Comments and decision on A/270/21/OUT From Angmering Parish Council

The current application, A/270/21/OUT, is a Hybrid application comprising:

APPENDIX B: PROPOSED DEVELOPMENT

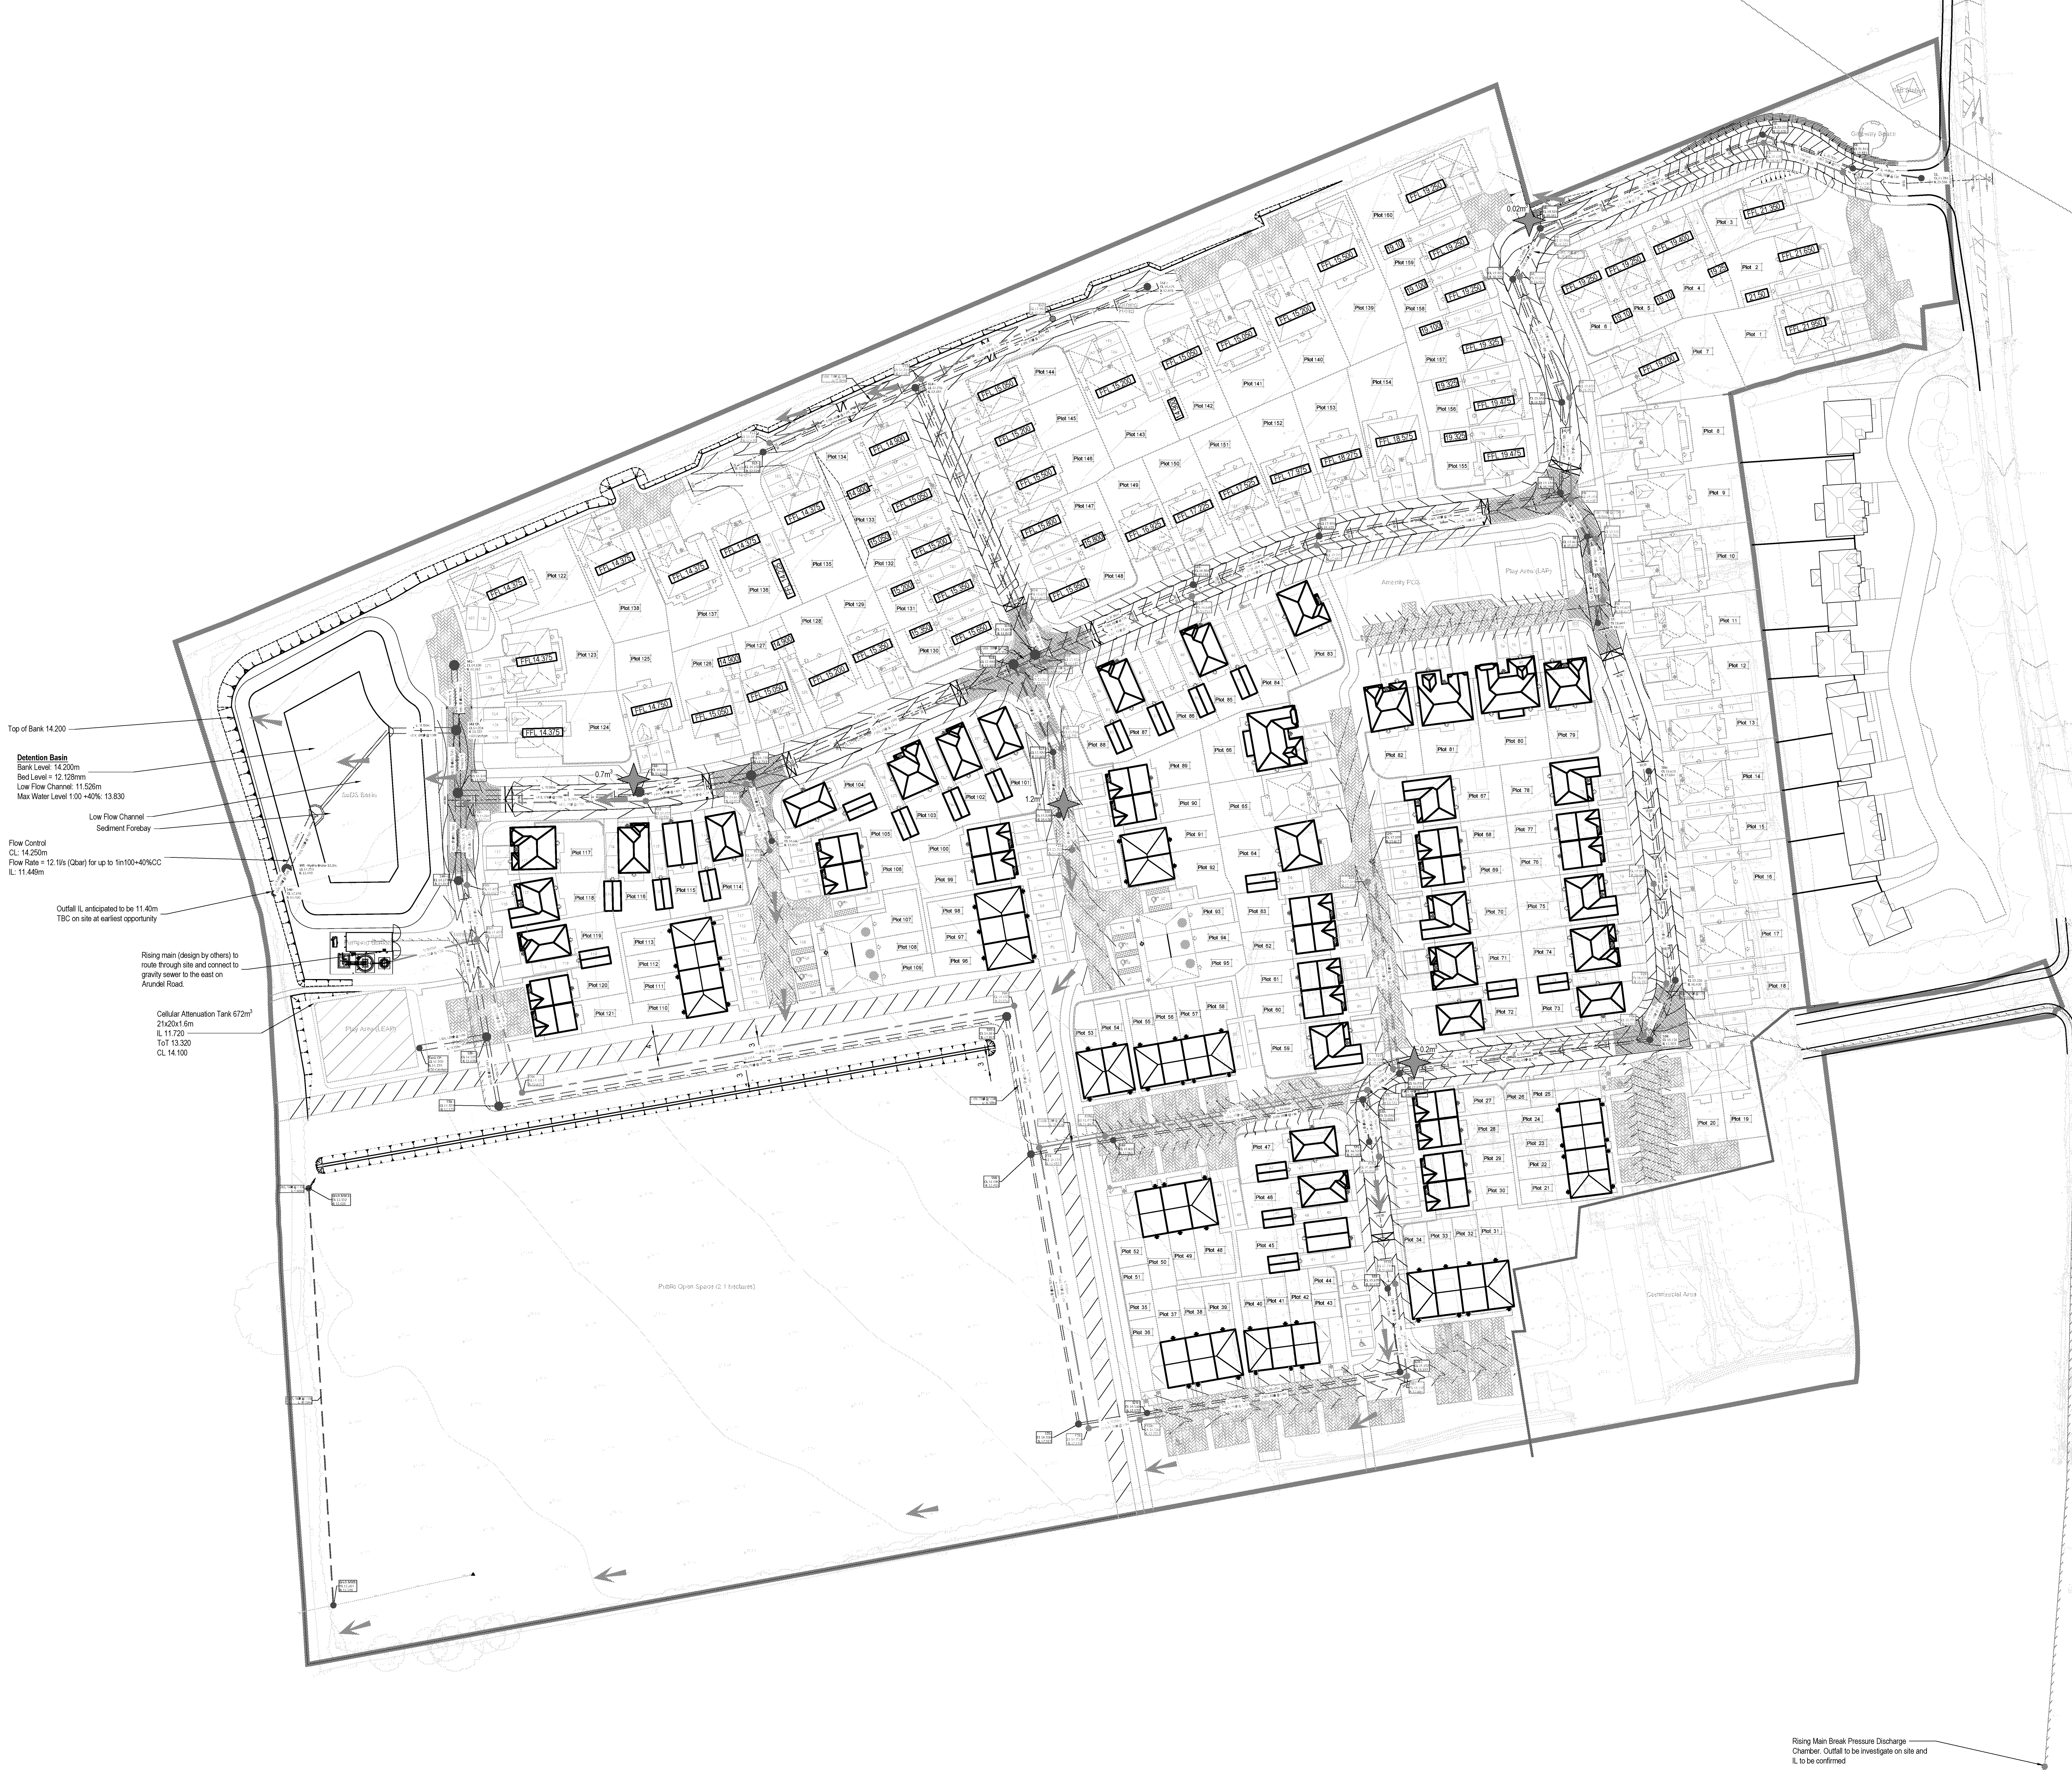
The residential part of the site is tightly packed and predominantly buildings and hard surfaces. Street trees are shown but given the lack of space around them, they are likely to be small and under pressure from the uses around them. Streets are dominated by frontage car parking, both parallel spaces along the streets and right angled parking in front of plots.

- The proposed layout of the residential element of the site is cramped, dominated by on-street and front of plot car parking and has insufficient space for the street trees shown on the plans or any other green infrastructure along the streets. As a result the scheme fails to provide high quality design reflecting local distinctiveness as required by Angmering Neighbourhood Plan policies HD5 and HD6.

In light of the above comments, the layout should be reconsidered to allow more space within the residential part of the site for creating an attractive streetscape that meets the requirements of Angmering Neighbourhood Plan policies HD5 and HD6 for high quality design which reflects
